Final Plat comment responses.pdf Markup Summary

**AS REPLATTED**

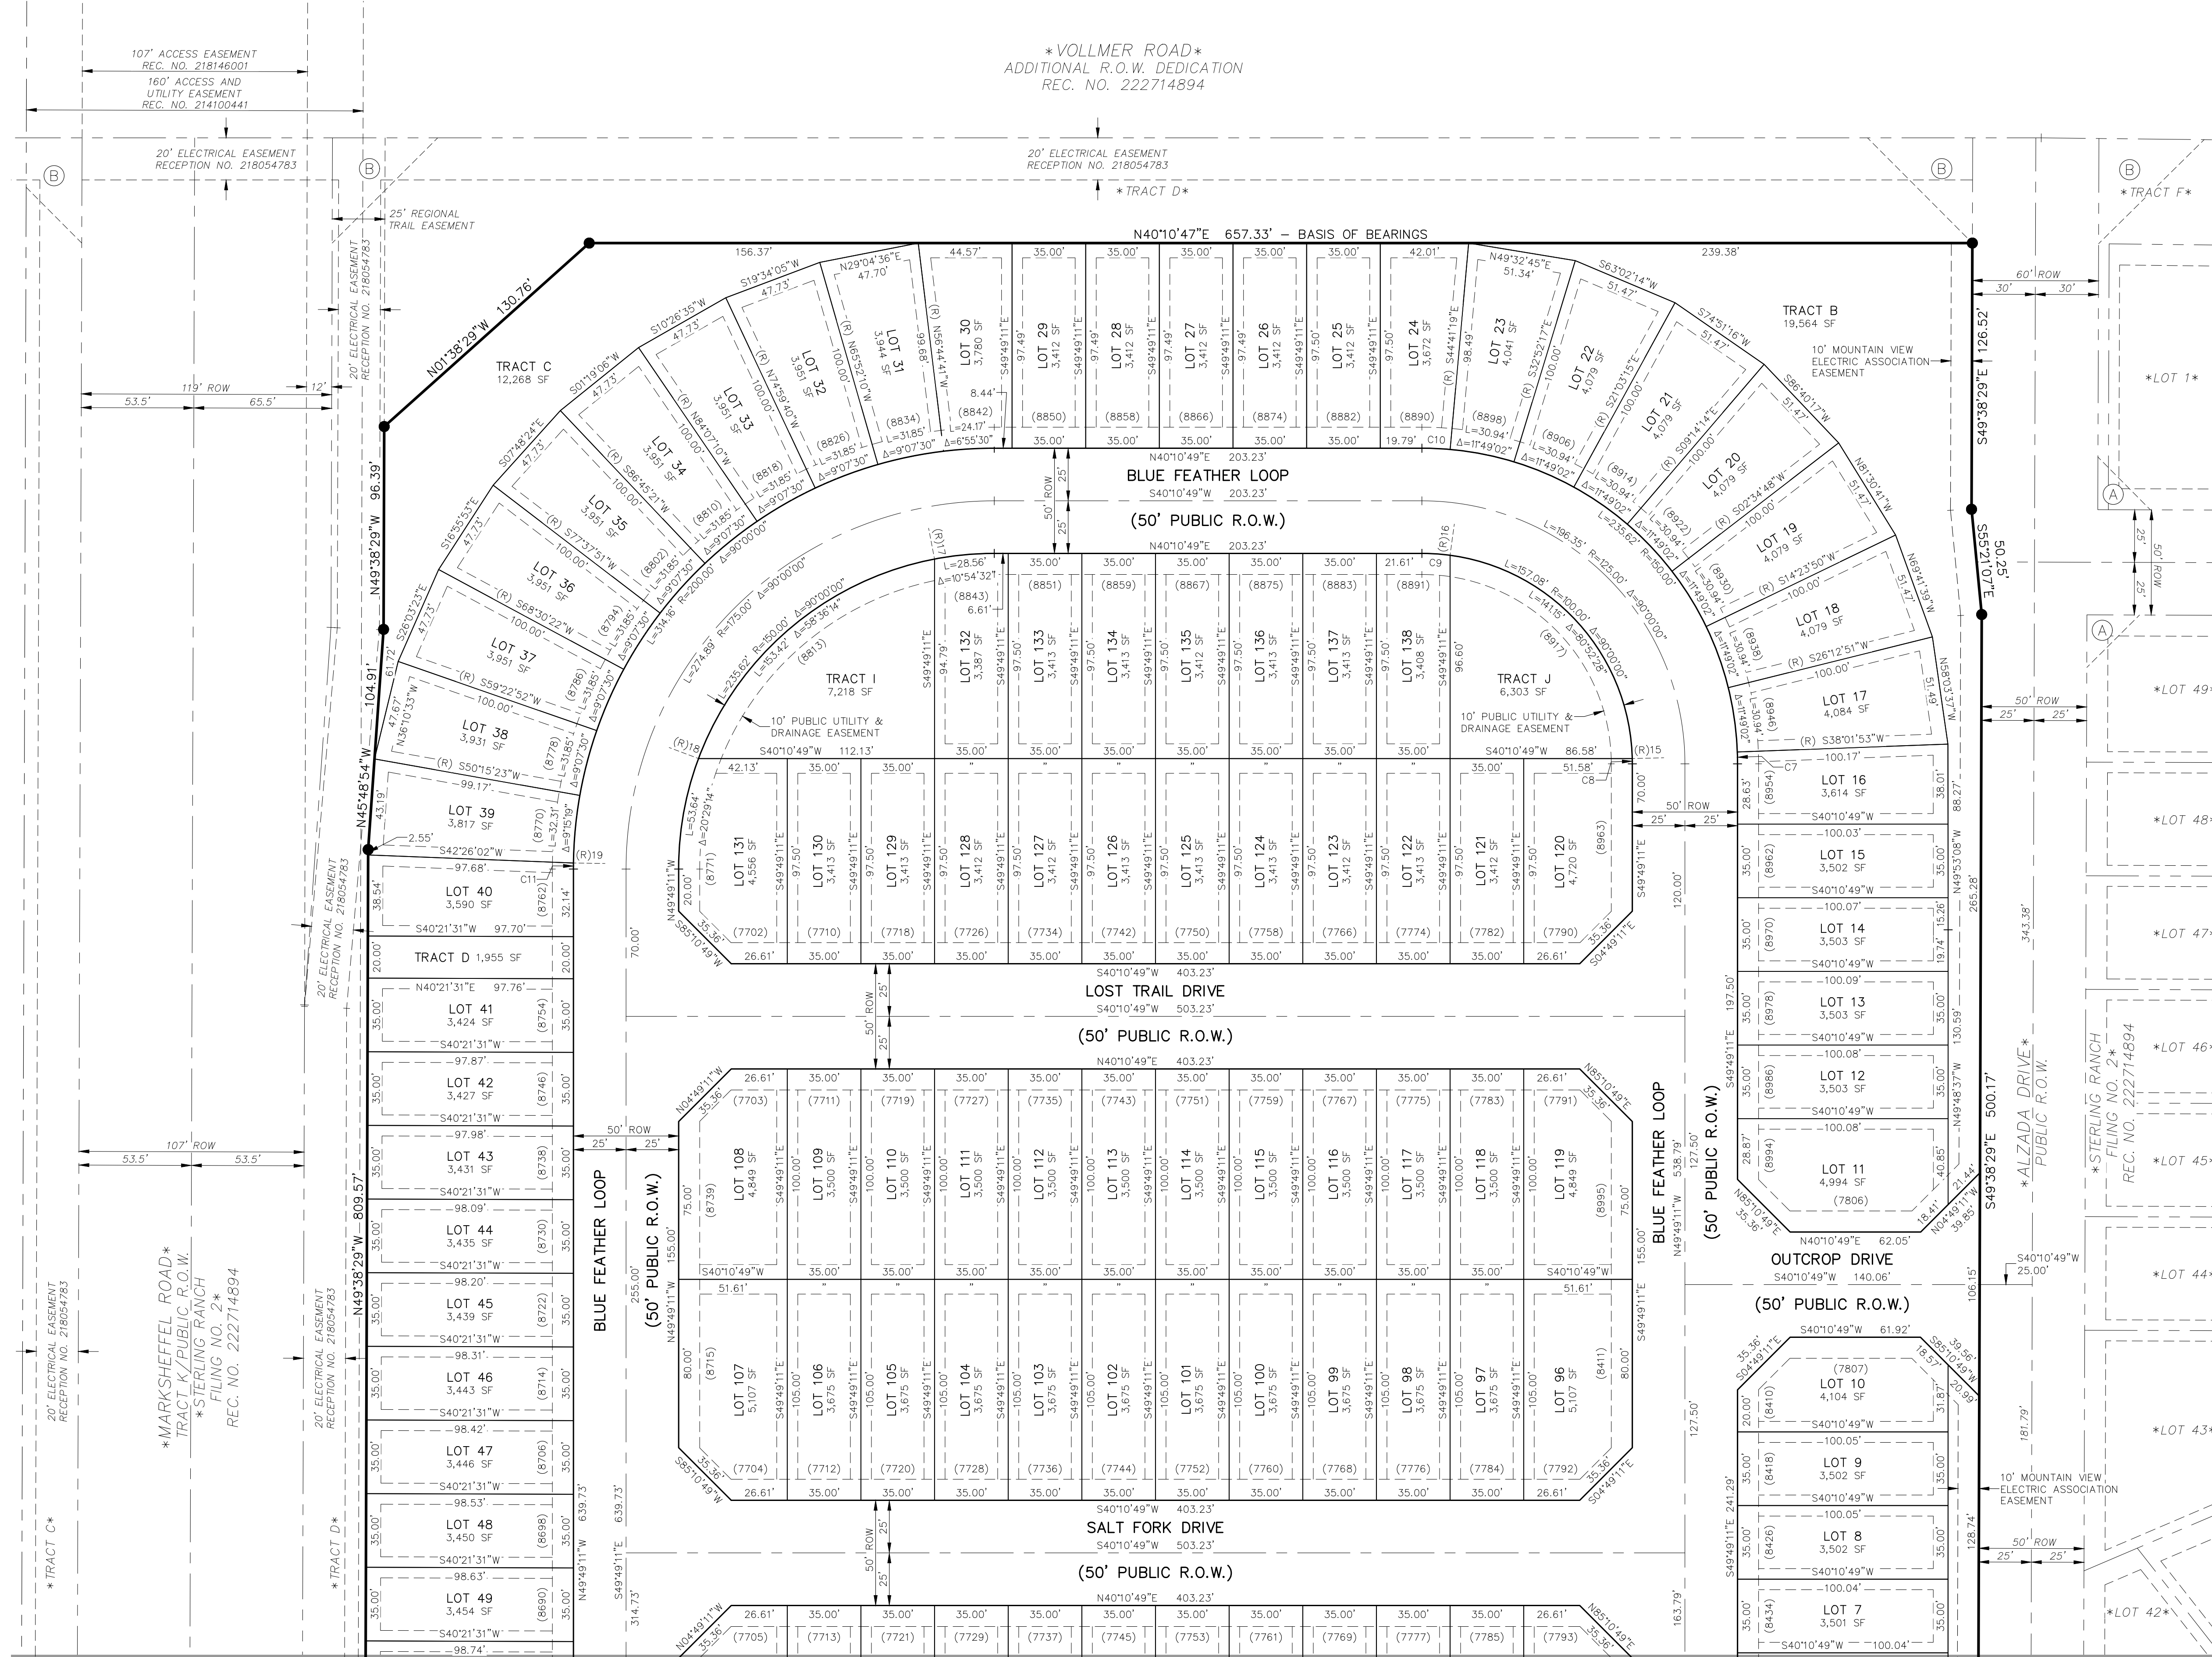
Subject: Callout
Page Label: Sheet 4 - As Replatted
Author: dsdparsons
Date: 6/28/2023 1:49:46 PM
Status:
Color: ■
Layer:
Space:

remove the public sidewalks from private lots- see PUDSP comments

Subject: Callout
Page Label: Sheet 4 - As Replatted
Author: dsdparsons
Date: 6/28/2023 1:51:06 PM
Status:
Color: ■
Layer:
Space:

this is a tract on the PUD; sidewalks need to be ROW not in lots

Subject: Callout
Page Label: Sheet 4 - As Replatted
Author: CDurham
Date: 6/28/2023 11:17:58 AM
Status:
Color: ■
Layer:
Space:

Tract needs to be provided for retaining wall (Comment from preliminary plan)

Subject: Text Box
Page Label: Sheet 4 - As Replatted
Author: dsdparsons
Date: 6/28/2023 1:56:15 PM
Status:
Color: ■
Layer:
Space:

comments on sheet 3 and 4 are repeated

All public improvements have been "moved" from private property to public rights-of-way; portions of lots and tracts formerly within sight visibility/public improvement easements have been added to dedicated rights-of-way.

Sidewalk in this location adjacent to Blue Feather Loop is within the ROW; no tract is necessary here.

Proposed retain wall has been eliminated, hence no tract will be needed.

Repeated comments applying to sheets 3 and 4
have been addressed.
